SUNDALE NORTHLAND DEVELOPMENT PTY LTD

ACCESS DESIGN REVIEW – DEVELOPMENT APPLICATION (DA)

12-16 Bent Street, Lindfield NSW

Date: 3 October 2025

Drawing Number: AR-B10030

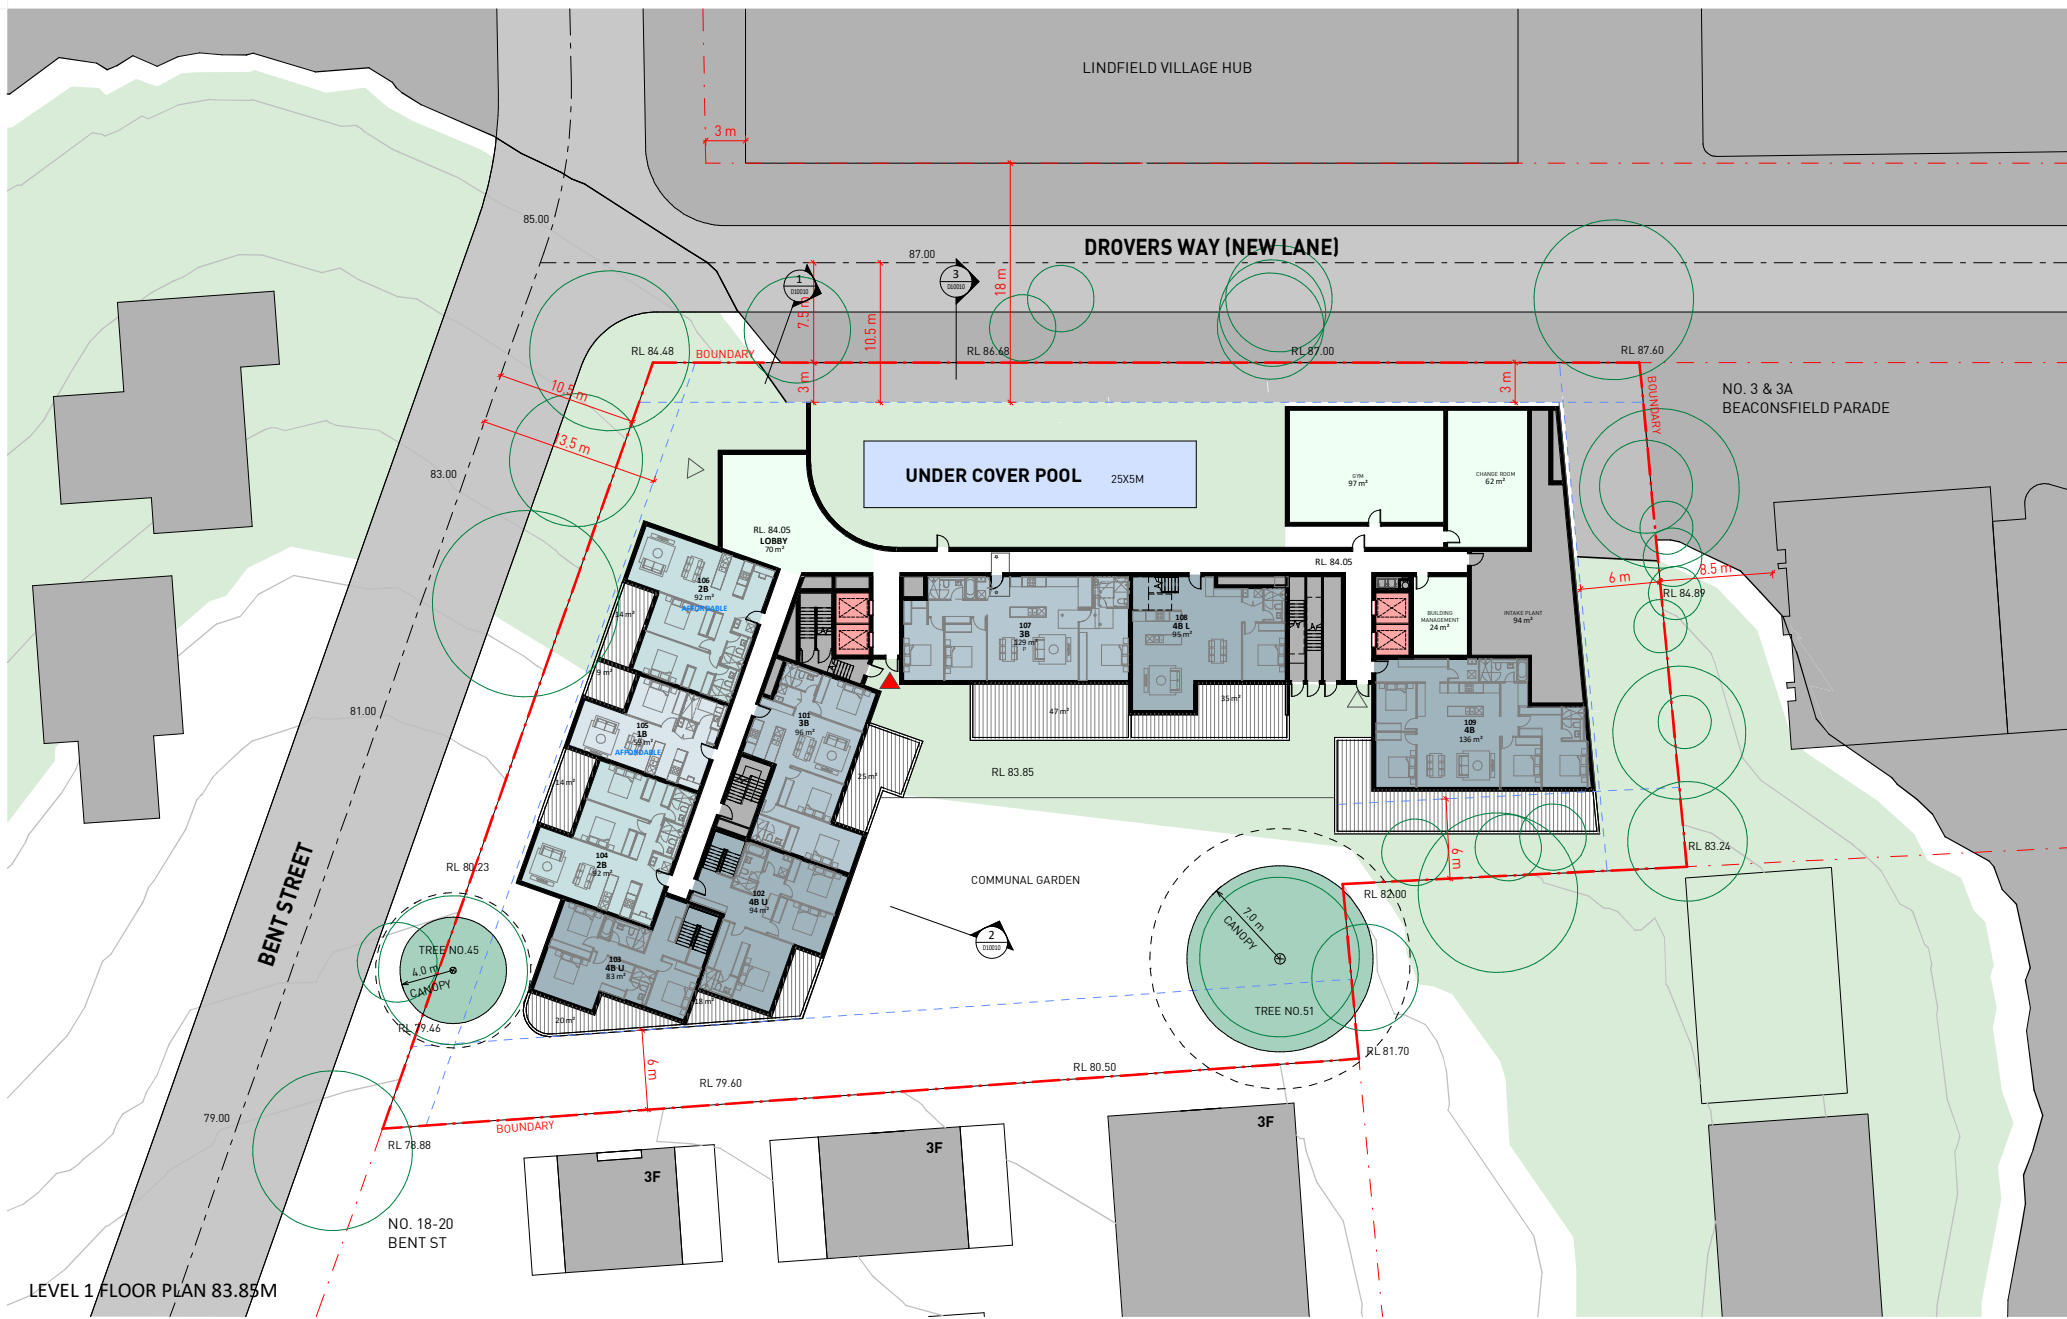
1. For the proposed accessways noted in **Part 3.9.2** of this report, consider the following technical provisions of AS1428.1-2021 related to walkways and landings to satisfy compliance and ensure that they can be addressed as the design progresses:

- **1:20** walkways require landings at intervals no greater than **15m** in line with Clause 7.2(b)(ii) of AS1428.1-2021.
- **1:22** walkways require landings at intervals no greater than **16.54mm** in line with Clause 7.2(b)(iii) of AS1428.1-2021.

- The walkways shall comply with Clause 7.4 for curved walkways and Clause 4.2 of AS1428.1-2021 for the abutment of the sides.
- Landings (on a 1:40 gradient) shall be provided at all changes in direction in accordance with Clause 7.8 of AS1428.1-221 which requires **1200mm** (Figure 25 (A) in length where there is no change in direction, **1500mm** (Figure 25(B) where there is a change of direction not exceeding 90 degrees and for a 180 degree turn, the landing shall be as shown in Figure 25(C).

- A turning space complying with AS1428.1-2021 (1540mm wide x 2070mm long) is required at maximum 20m intervals along the accessways (walkway) as per D4D4(c)(ii)(B) of the BCA.

- A passing space complying with AS1428.1-2021(1800mm x 2000mm) is required at maximum 20m intervals on those parts of an accessway where a direct line of sight is not available.

2. The general communication stairway noted on Level 01 (serving the communal garden) and the stairway serving the secondary access points to the SOUs is to provide dual handrails, 1m clear width between handrails, extensions/terminations as per AS1428.1-2021 and TGSIs as per AS14284.1-2009. This is capable of being addressed post-DA, however, is to be considered by the design team as the design progresses.
